Determination of Thomas Street Car Park Site Modification 6

The above modification application lodged by Meriton Property Services Pty Ltd (the proponent) has been referred to the Planning Assessment Commission (the Commission) for determination under Ministerial delegation dated 14 September 2011. The delegation is authorised because more than 25 submissions in the nature of objections were received.

A-0202-4 D
SECTION 75W MODIFICATION 6

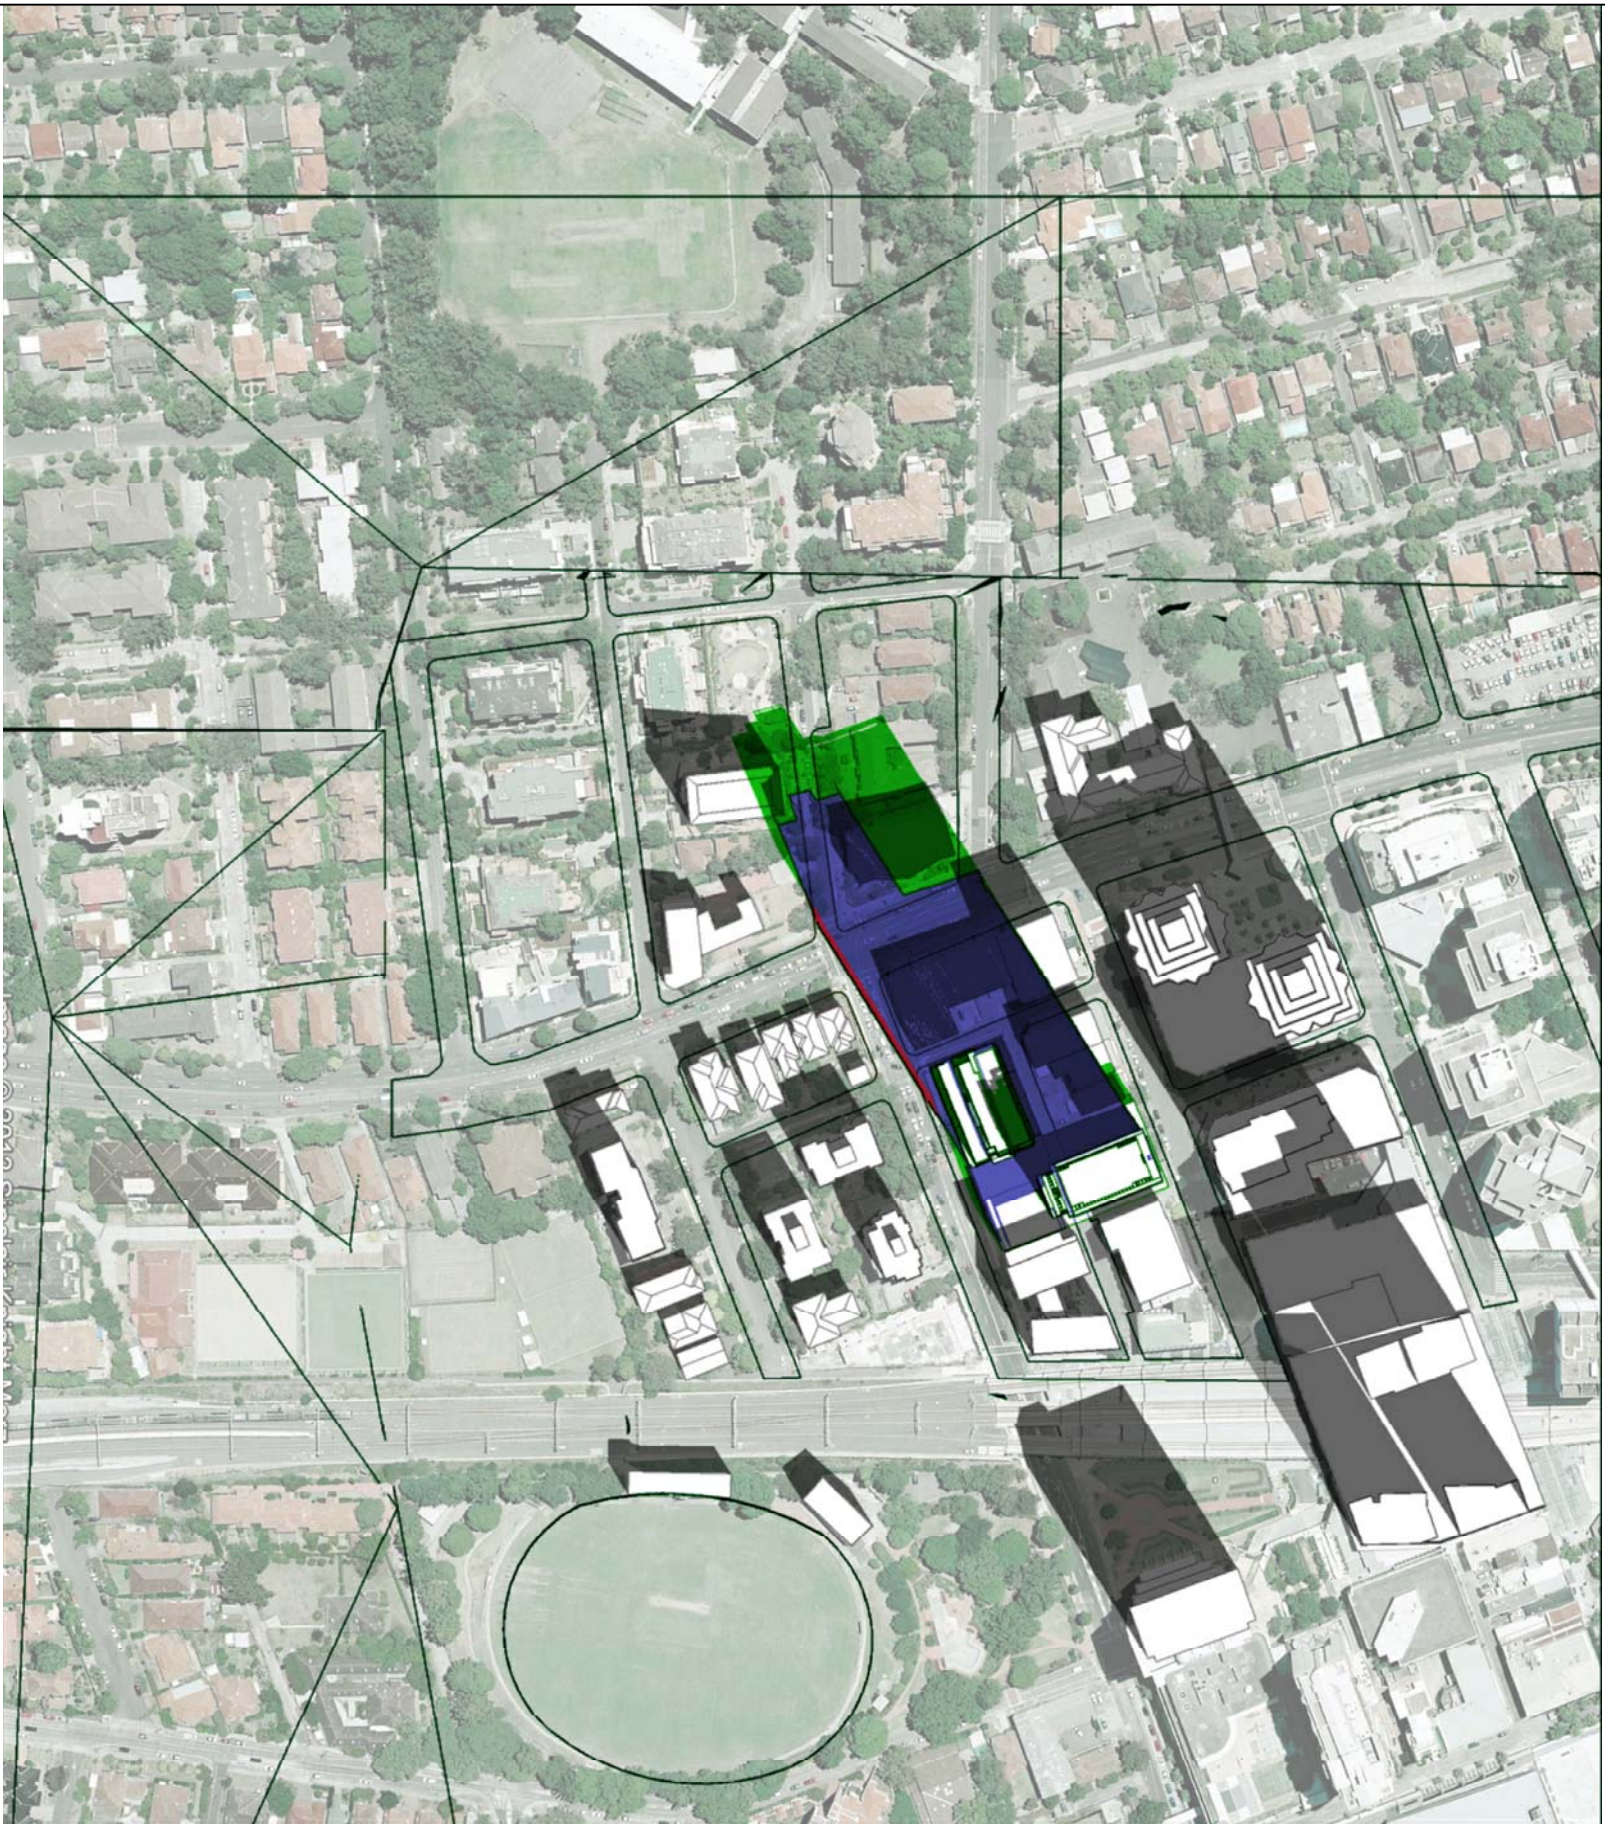
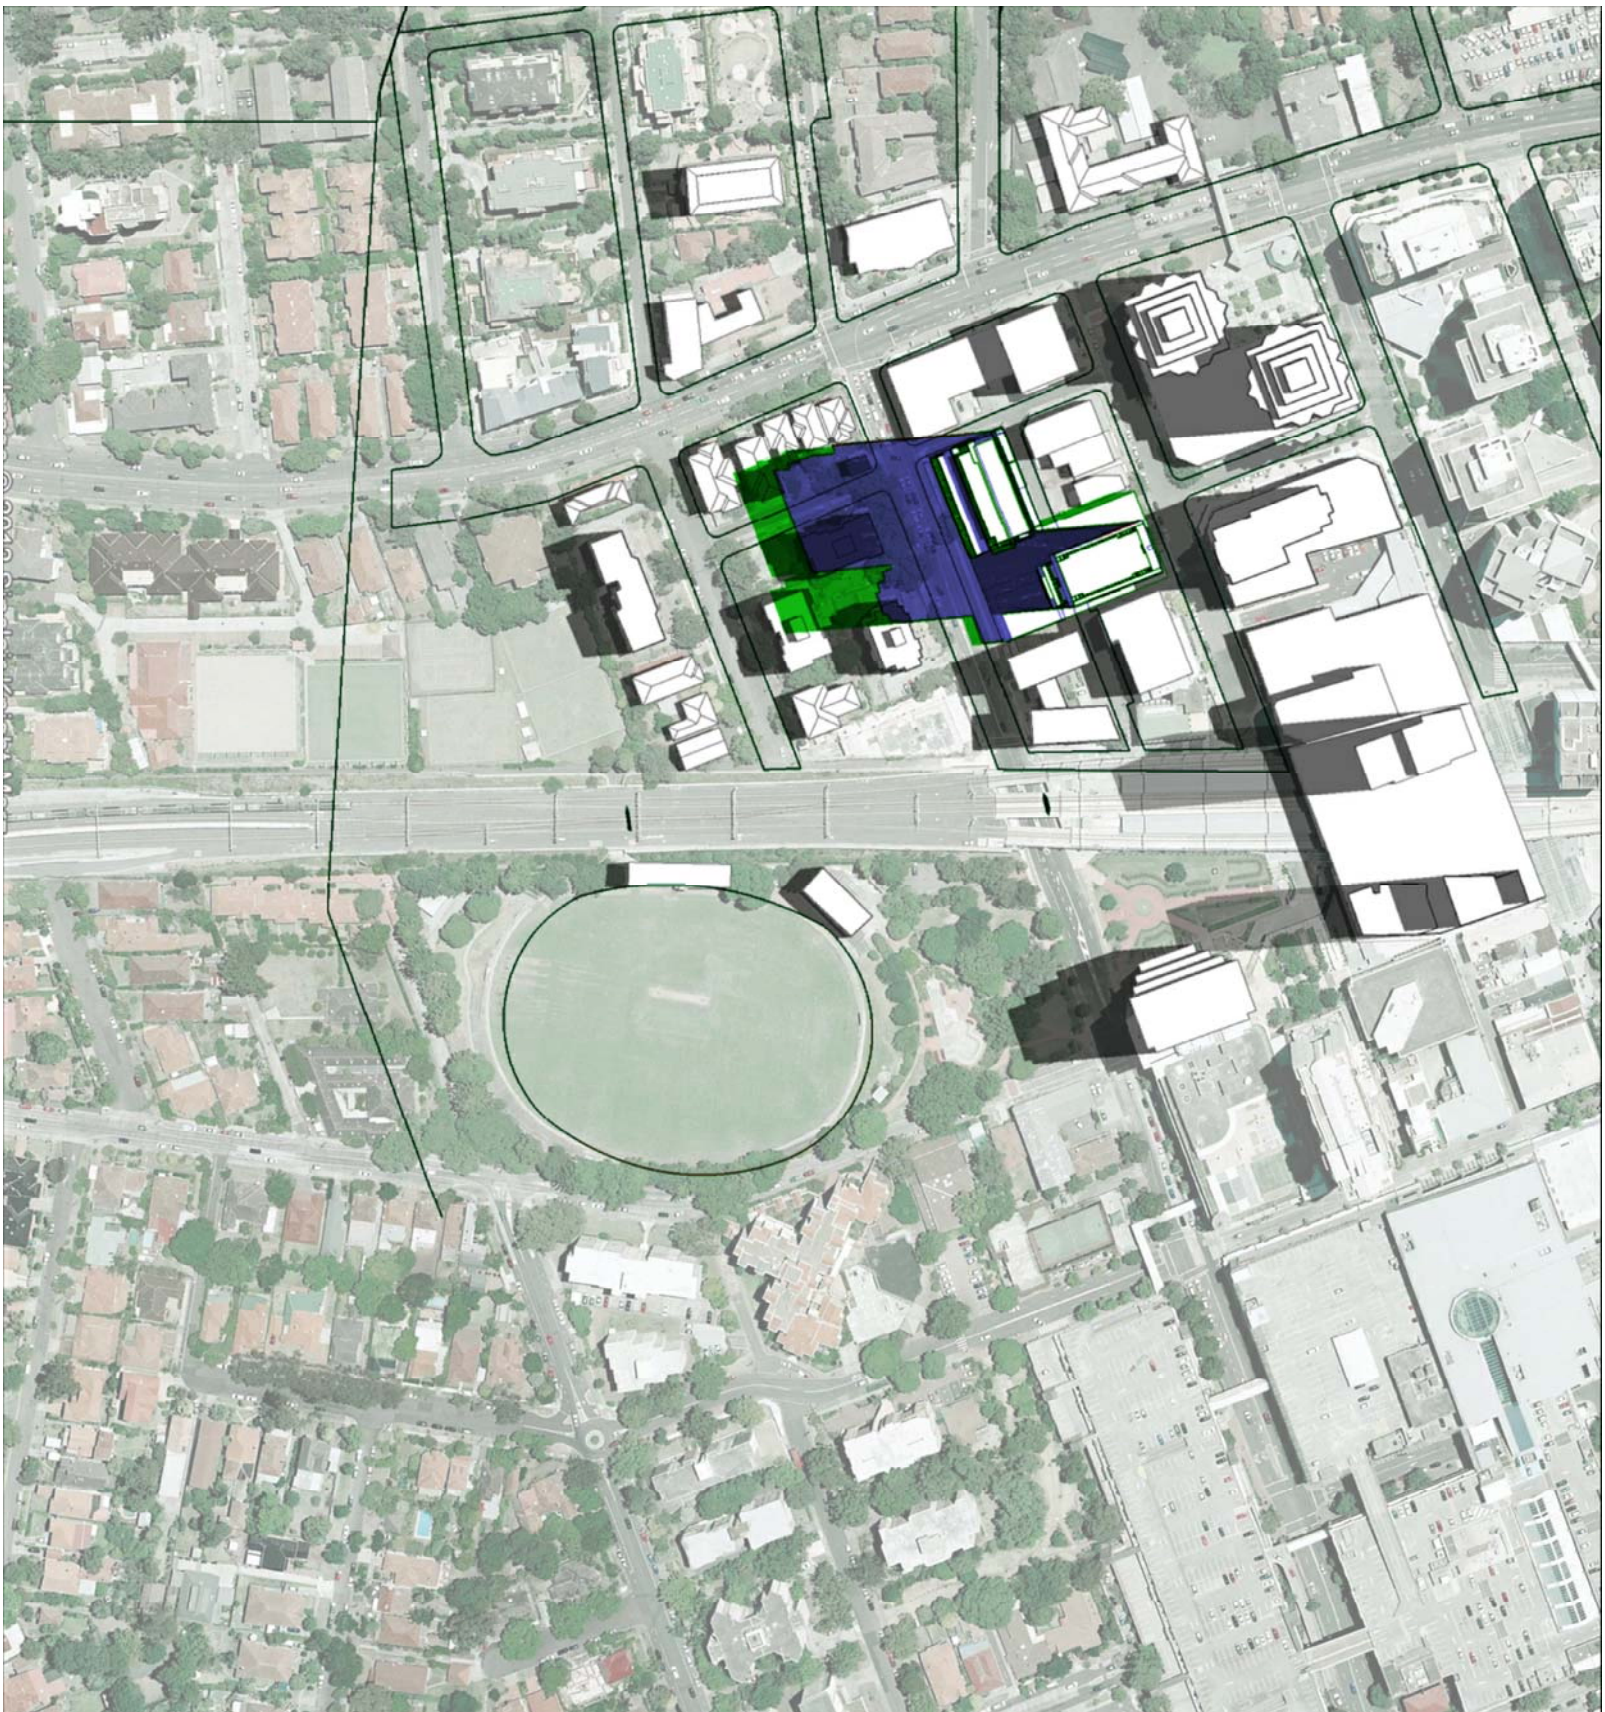
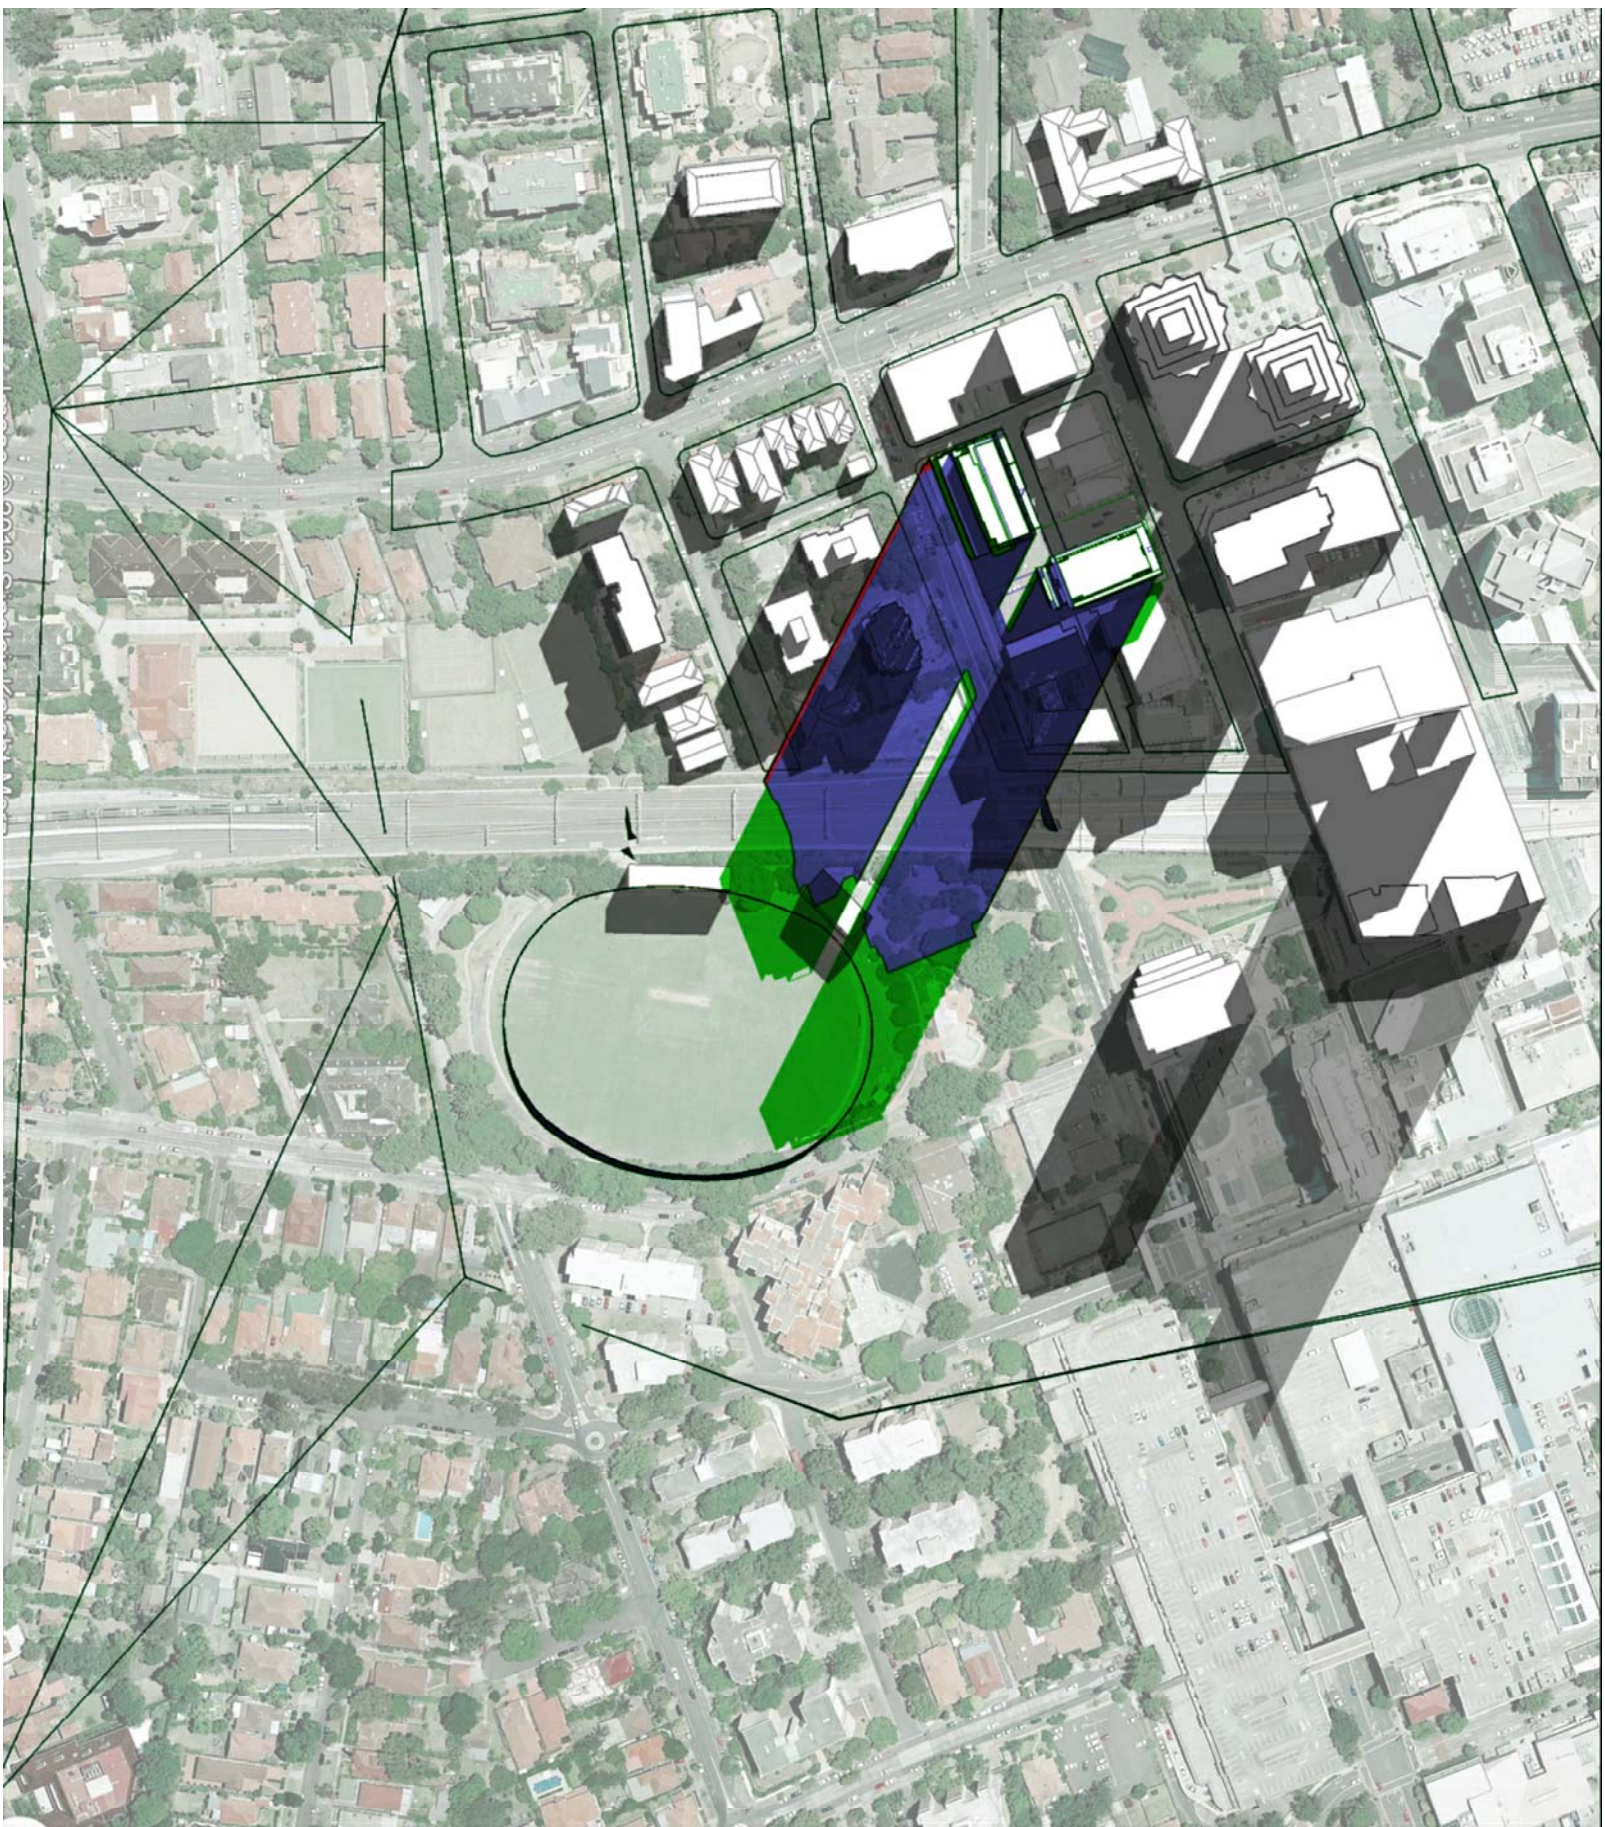
The Commission closely reviewed the shadow diagrams submitted by the proponent and found inconsistencies. It requested additional detailed shadow diagrams (weekly diagrams on hourly base between 31 March to 30 June) to clarify the extent of the impacts (between April and September) and these were supplied by the proponent on 19 September 2013.

The shadow diagrams show that there are already shadows being cast over the Oval by the approved development and other existing buildings. They also show the impact of this application (Mod 6) during the period from around 7 April to around 23 September, commencing at approximately 2.15pm. During this period, there are new shadows cast over the oval in locations that were previously sunlit.

These new shadows are essentially removing much of the limited sunlight that does reach the oval in the afternoon and would make the oval mostly shaded. The Commission considers this to be a very negative outcome, and is of view that just because the oval receives relatively good morning exposure in the period, this does not offset the negative impact in the afternoons.

A wider residential area will be subjected to new overshadowing as a result of the proposed increase in height of the towers. This occurs both during the mornings and afternoons, and is greatest in the months from April to September. The Commission agrees with the Department that these new shadows are moving quite quickly over the properties that are impacted.

The assessment report concludes that the impact of the overshadowing can be mitigated by a reduction of 5 storeys to the residential tower. The Commission has reviewed the result of such a reduction in height and does not consider the overshadowing outcome is adequately mitigated. The recommended height reduction would only reduce the impact to a minor extent. The Commission notes that Council expressed a similar view at the public meeting.
